Demolition of existing single storey side extension and construction of an attached two storey self contained dwelling.

> From: Fiona Rae <FRae@hillingdon.gov.uk>
> Date: 11 October 2022 at 17:39:15 BST
> To: enquiries@greystokebuilders.com
> Cc: Katie Crosbie <KCrosbie@hillingdon.gov.uk>
> Subject: 2 Worcester Rd

> Please can you ask your agent to re-submit the application with the access issues resolved. What we need to address are:

Description: PROPOSED ELEVATION & BLOCK PLAN.

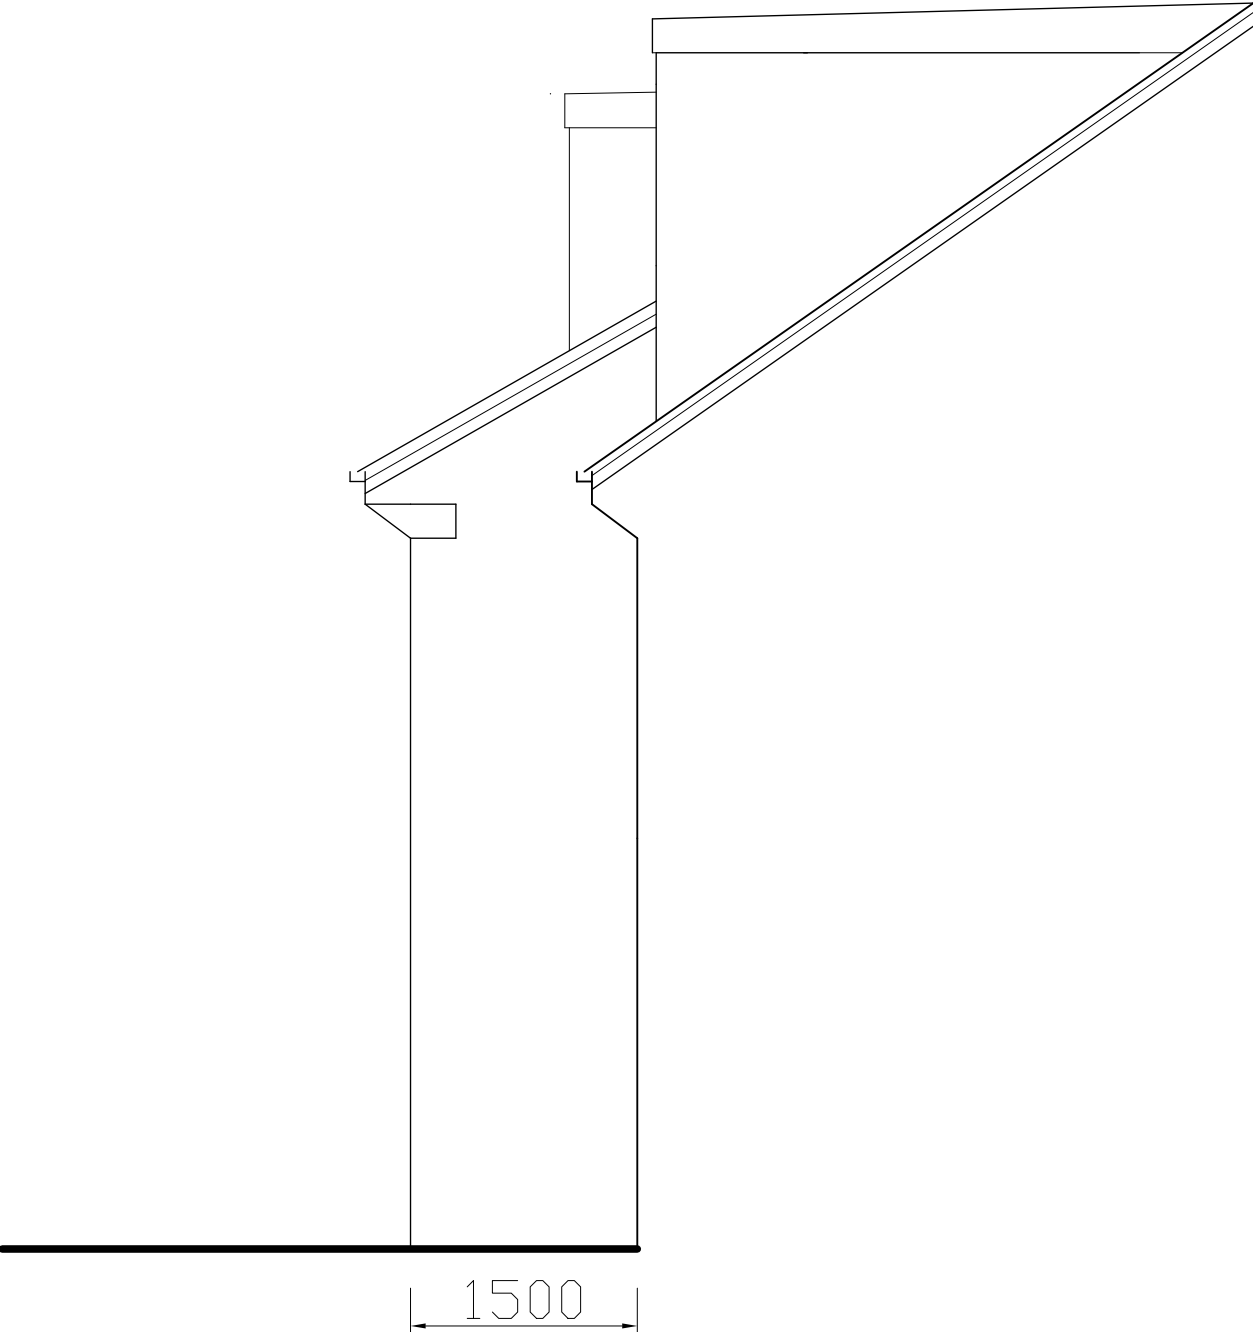
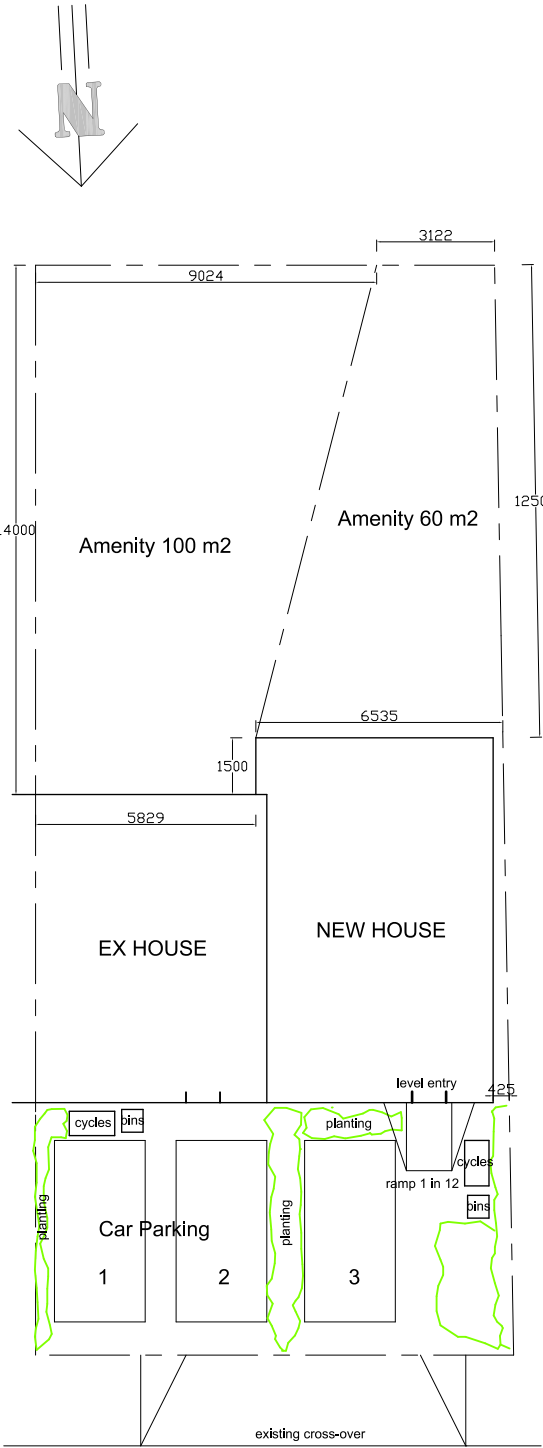
> 1. Step free access into the dwelling is required and details should be submitted to show this.
